EL PASO COUNTY GRADING AND EROSION CONTROL PLAN CHECKLIST

EPC Project Number: _____

Revised: July 2019

OFFSITE GRADING
(CANNOT BE COMPLETED
WITH EARLY GRADING PERMIT)

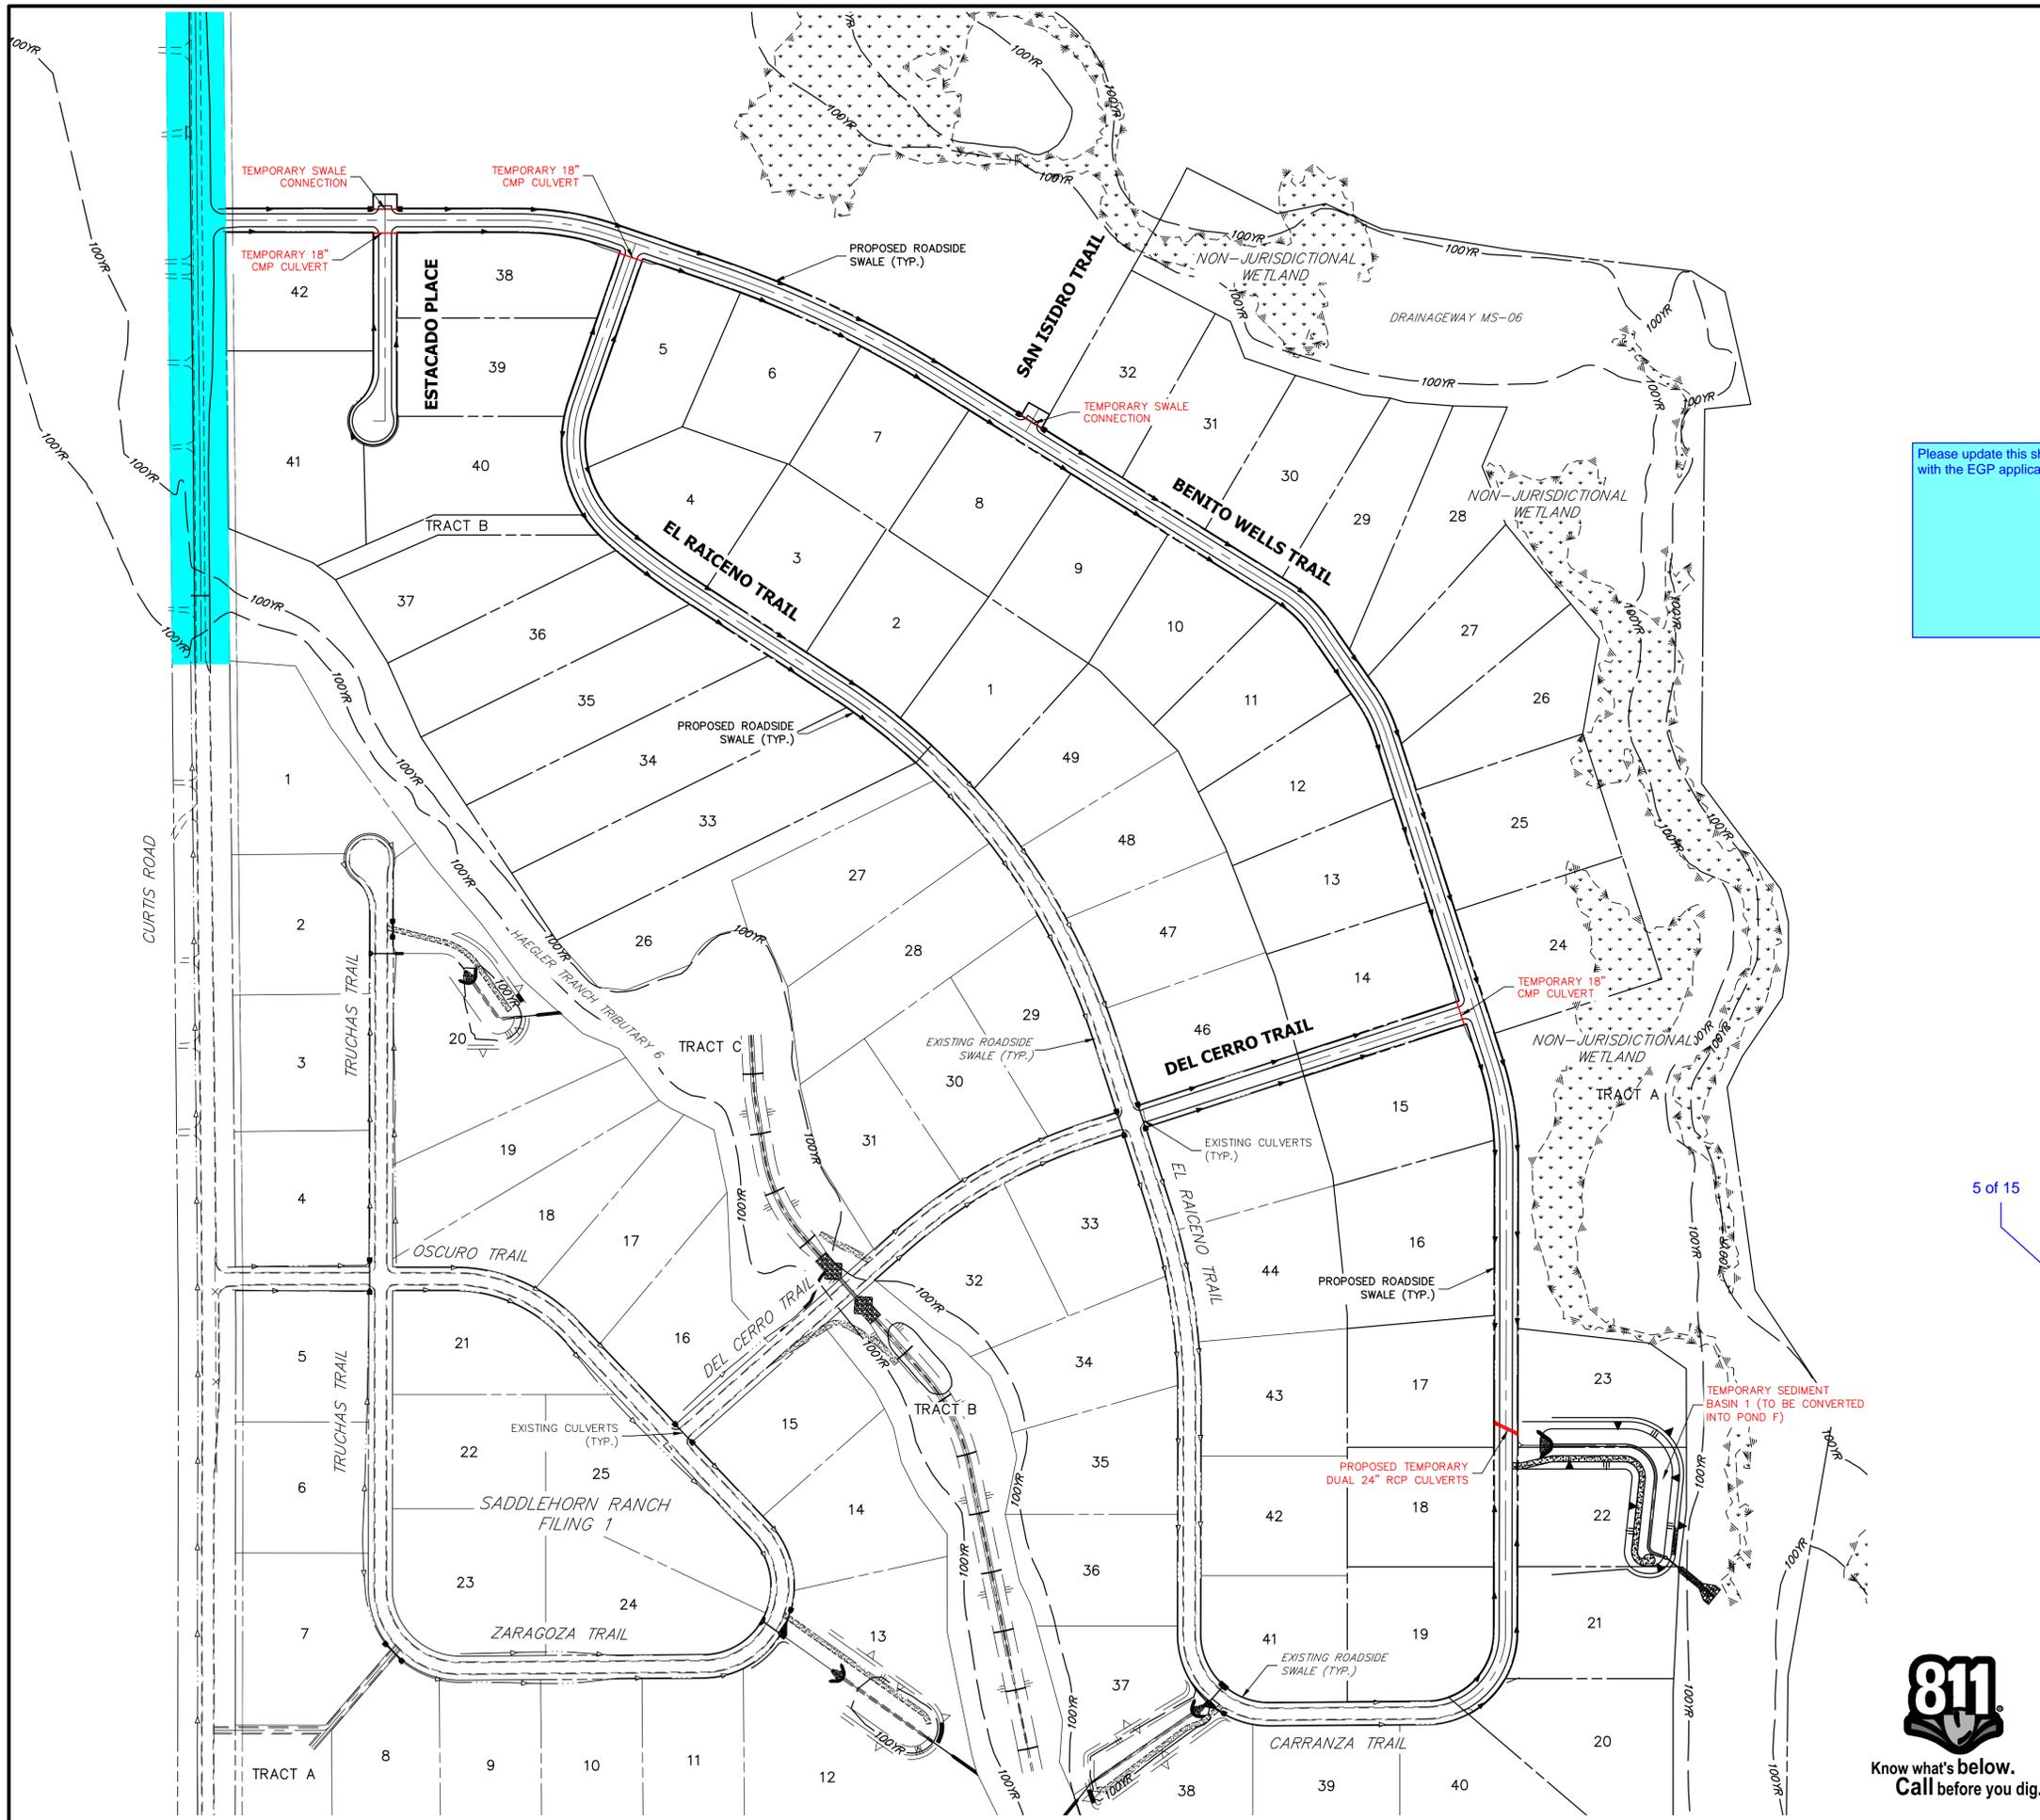
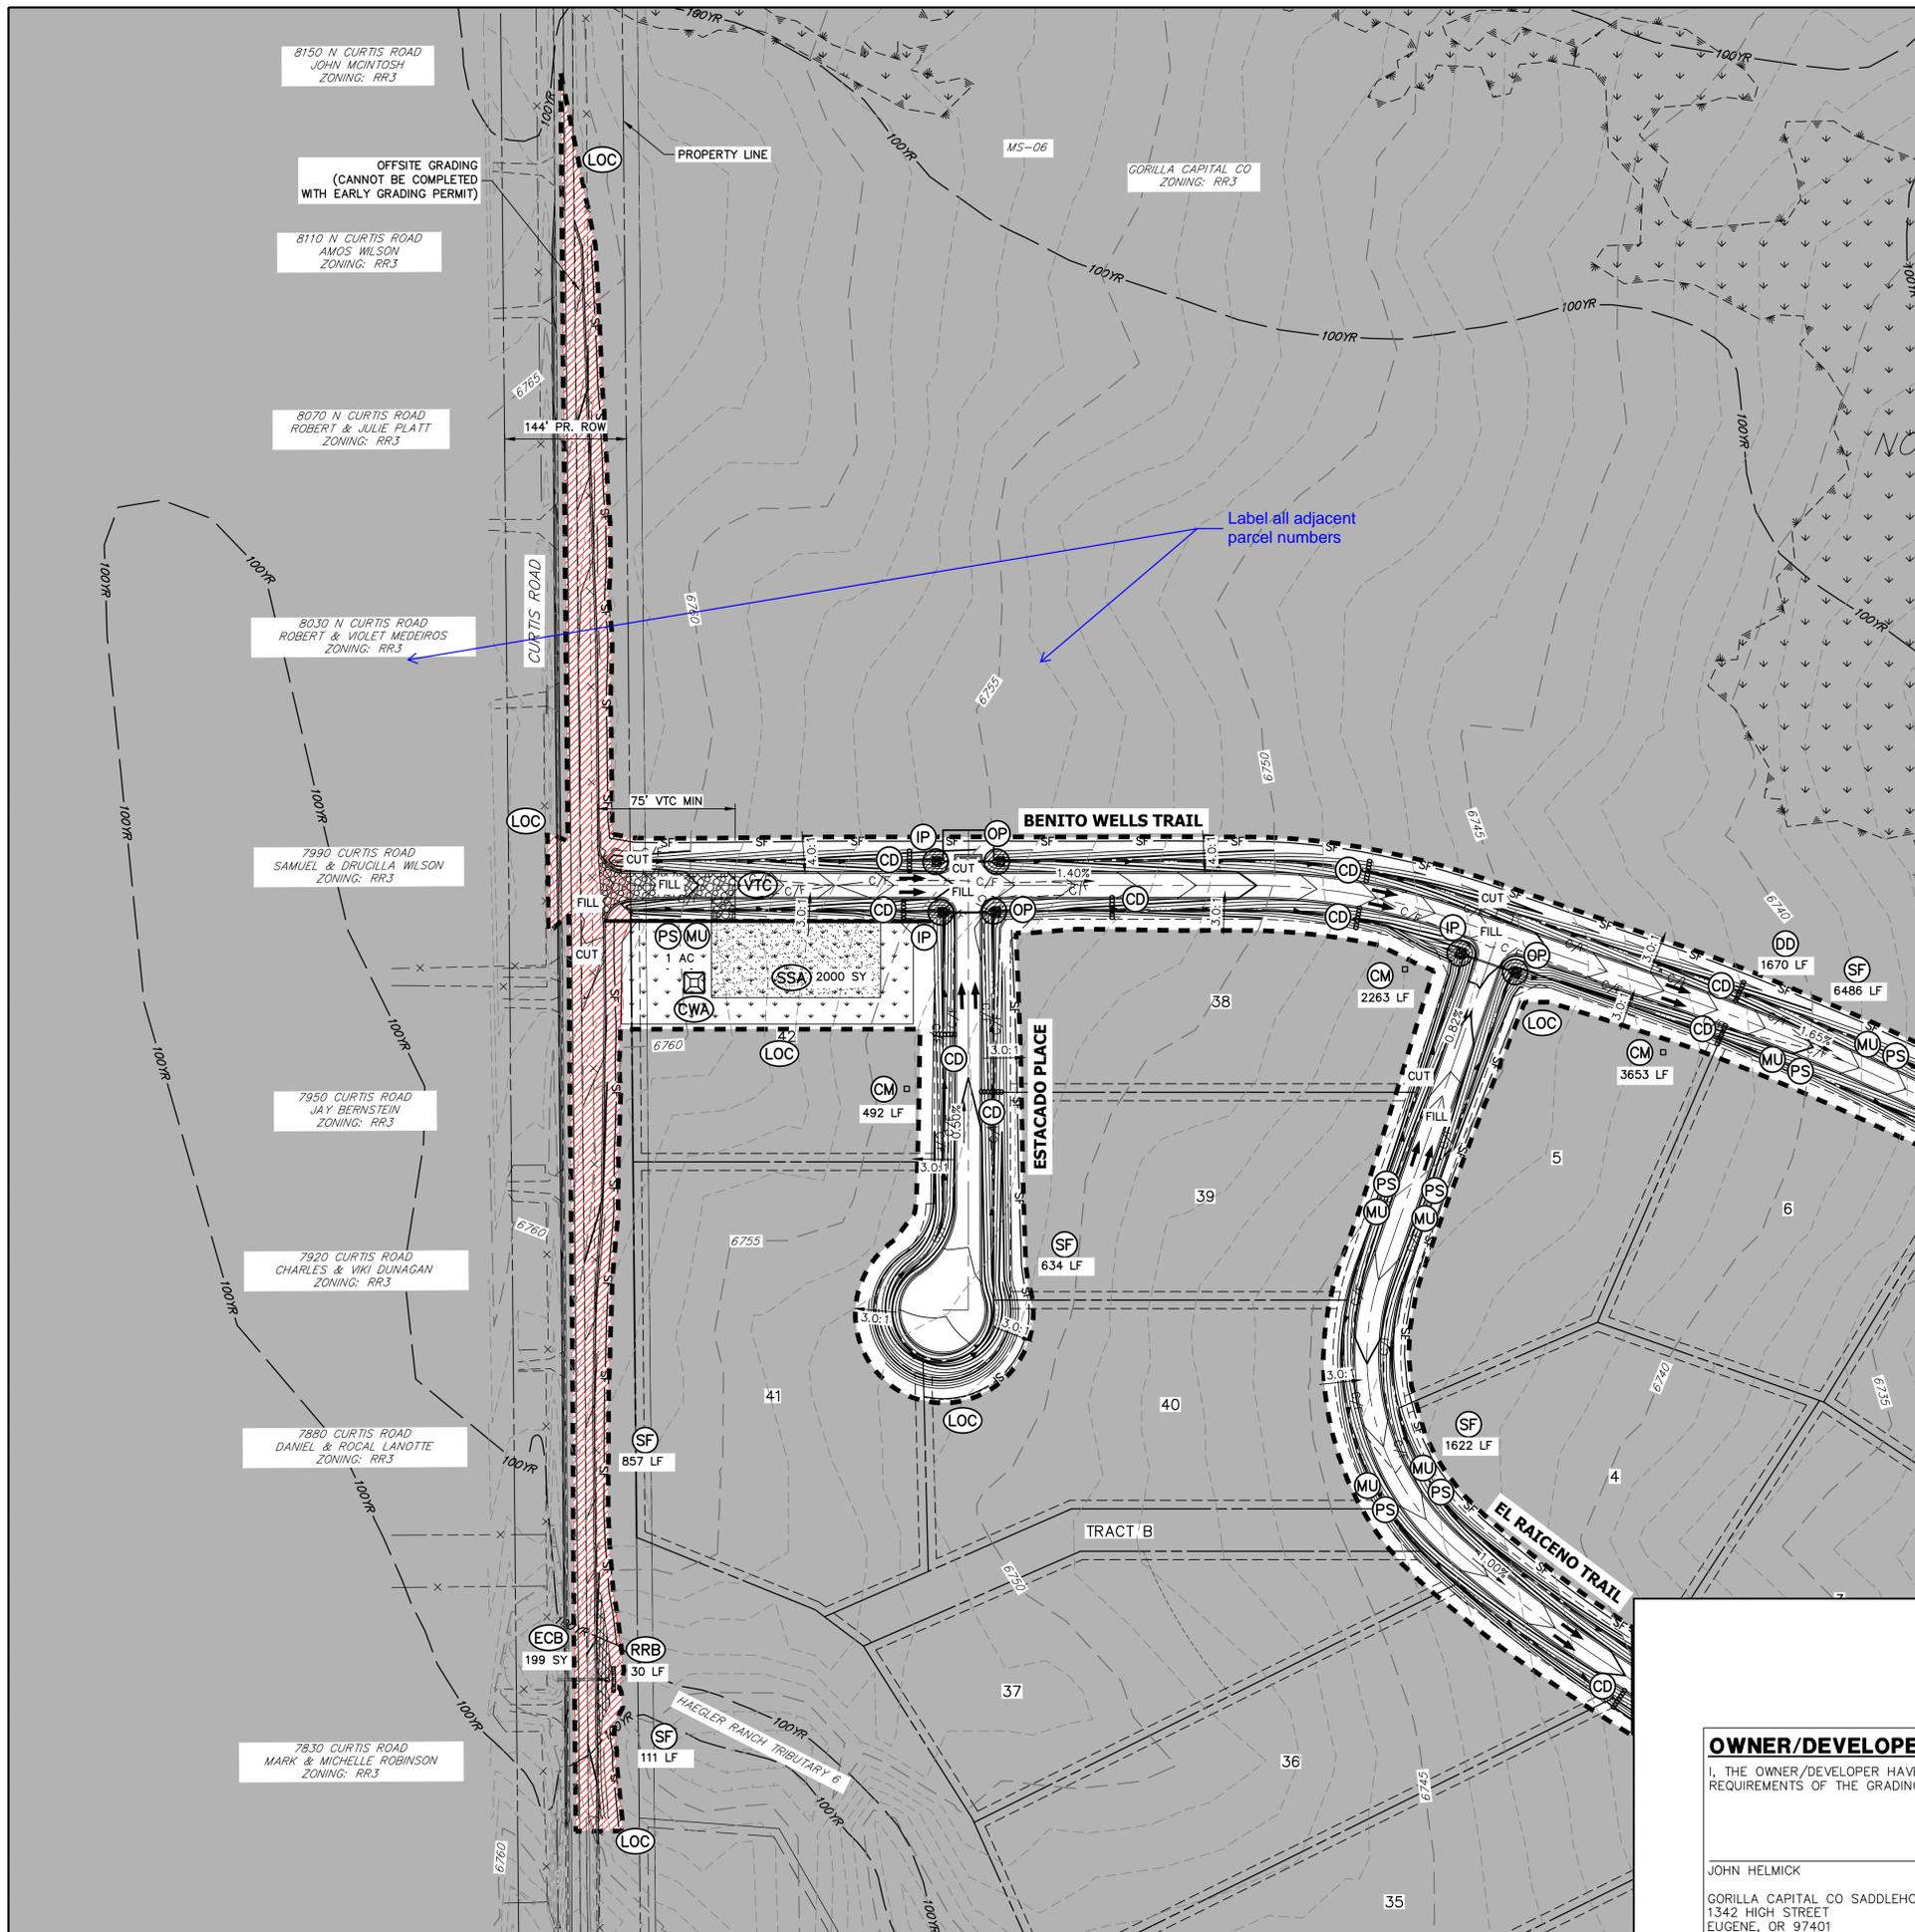
| | | Applicant | EPC |
|--|--|-----------|-----|
| b | Adjacent city/town/jurisdictional boundaries, subdivision names, and property parcel numbers labeled | | ✗ |
| d | Legend for all symbols used in the plan | | ✗ |
| m | Limits of disturbance delineating all anticipated areas of soil disturbance | | ✗ |
| o | Off-site grading clearly shown and called out | | ✗ |
| s | Stormwater flow direction arrows | | ✗ |
| w | Vehicle tracking provided at all construction entrances/exits. Construction fencing, barricades, and/or signage provided at access points not to be used for construction | | ✗ |
